Application for a non-material amendment following a grant of planning permission.

EXTENSION AND ALTERATIONS TO CARE HOME
(RE-SUBMISSION FOLLOWING F9/44/101)

F9/43/101

ALTERATION TO EXISTING AND APPROVED OFFICE SPACE
RELOCATION OF APPROVED WINDOW AND
OMISSION OF APPROVED DORMER WINDOW.

**PROPOSED**  
East Elevation  
June 2009  
3109-113B  
1:100@A3

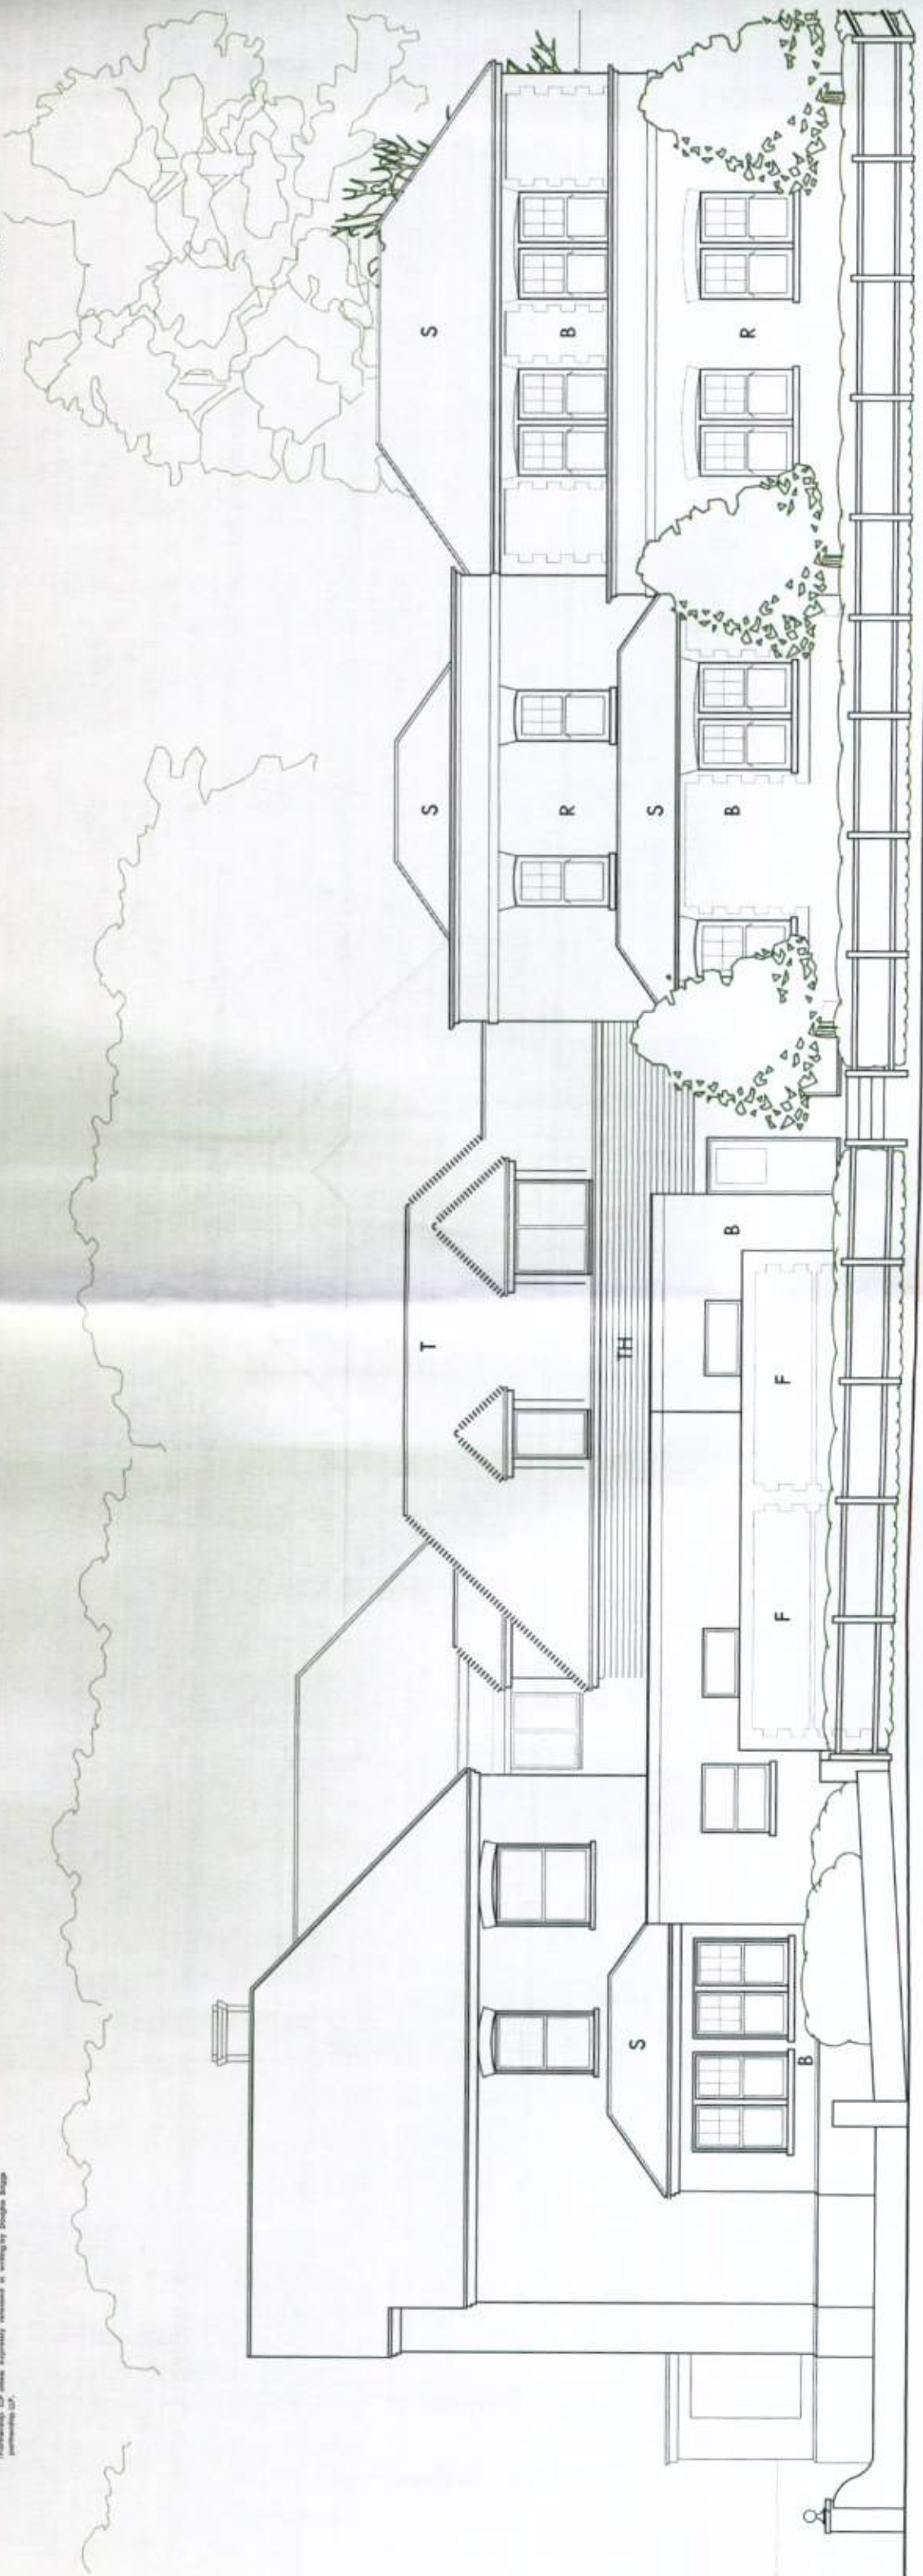
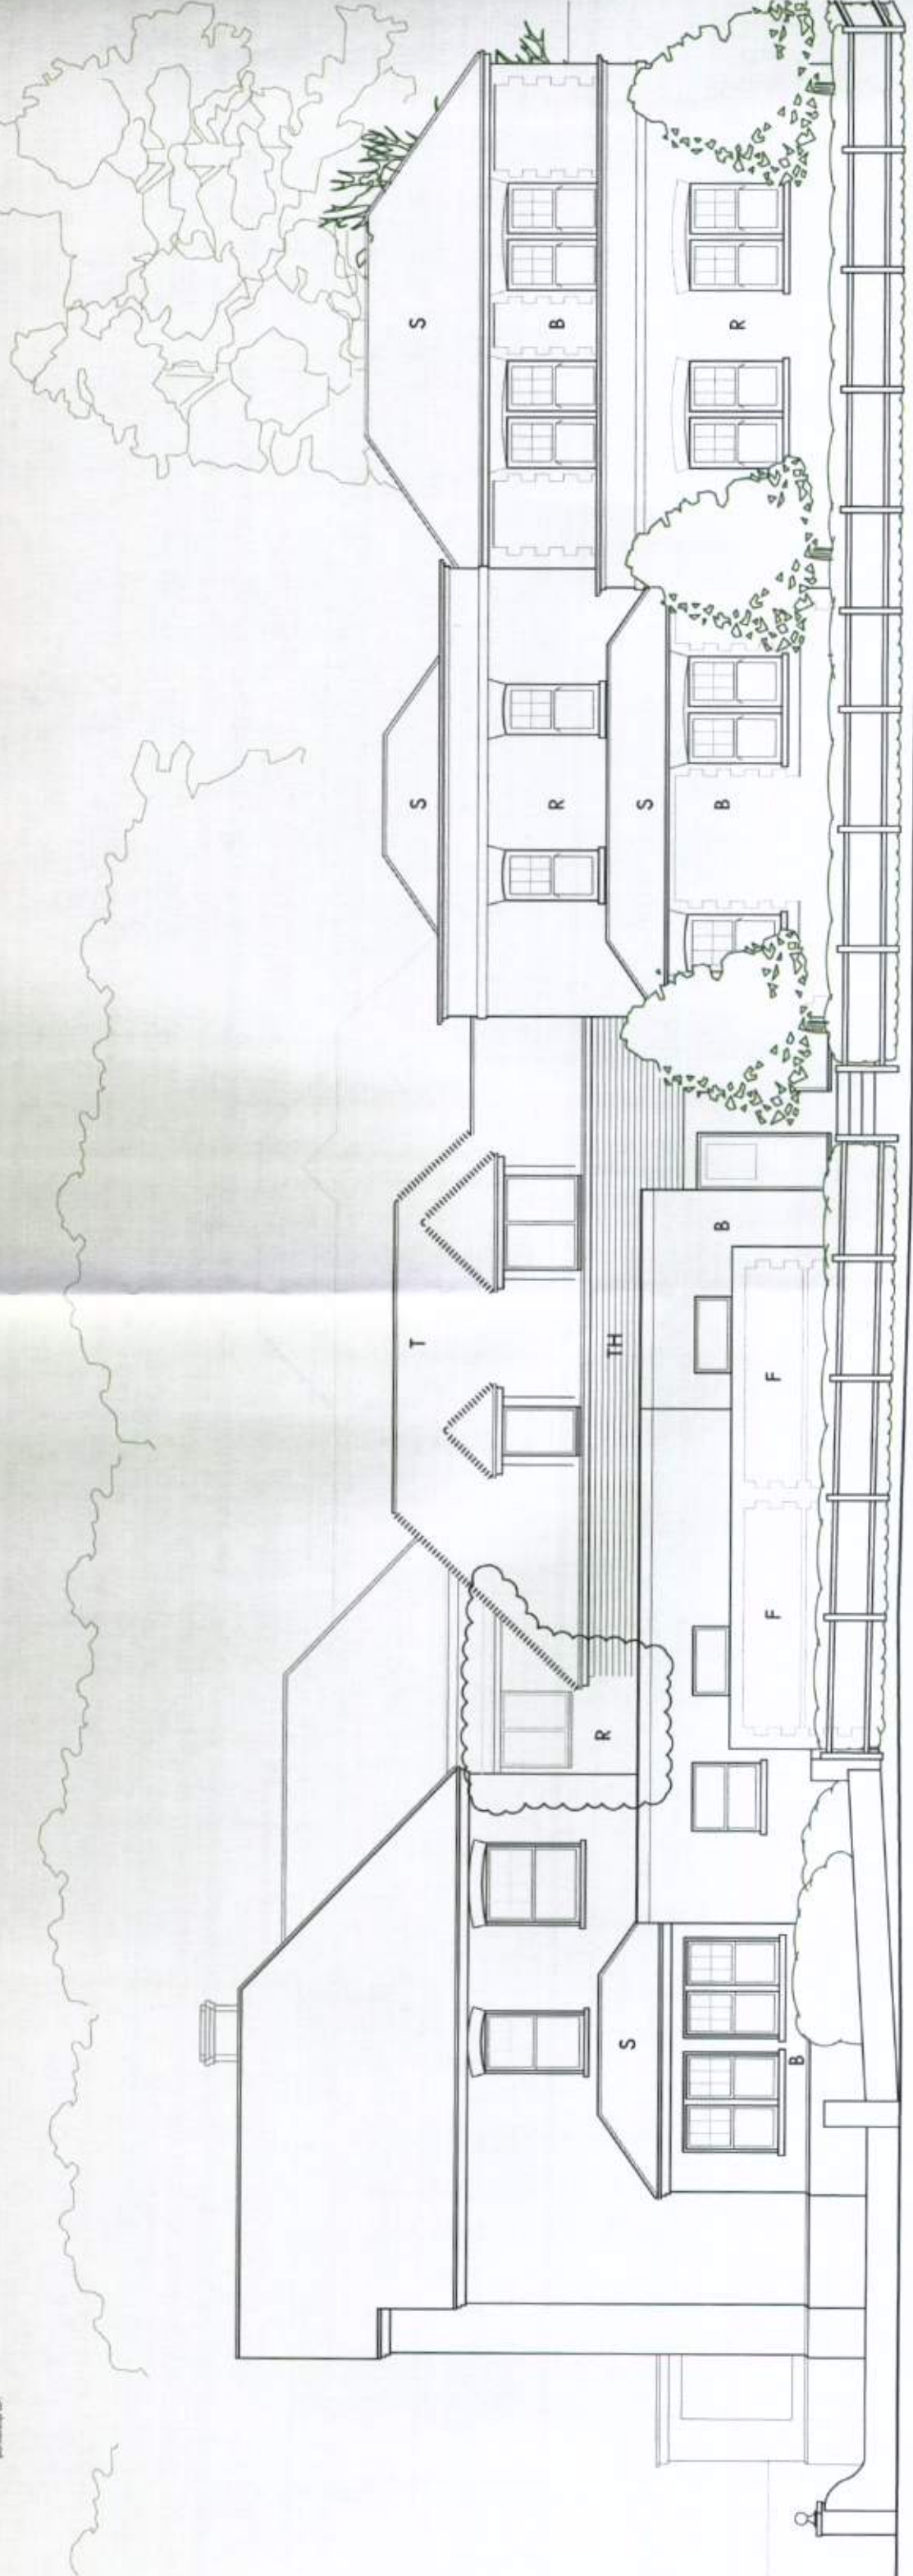
3109-110C, 3109-112C, 3109-113B

3109-110D, 3109-112D, 3109-113C
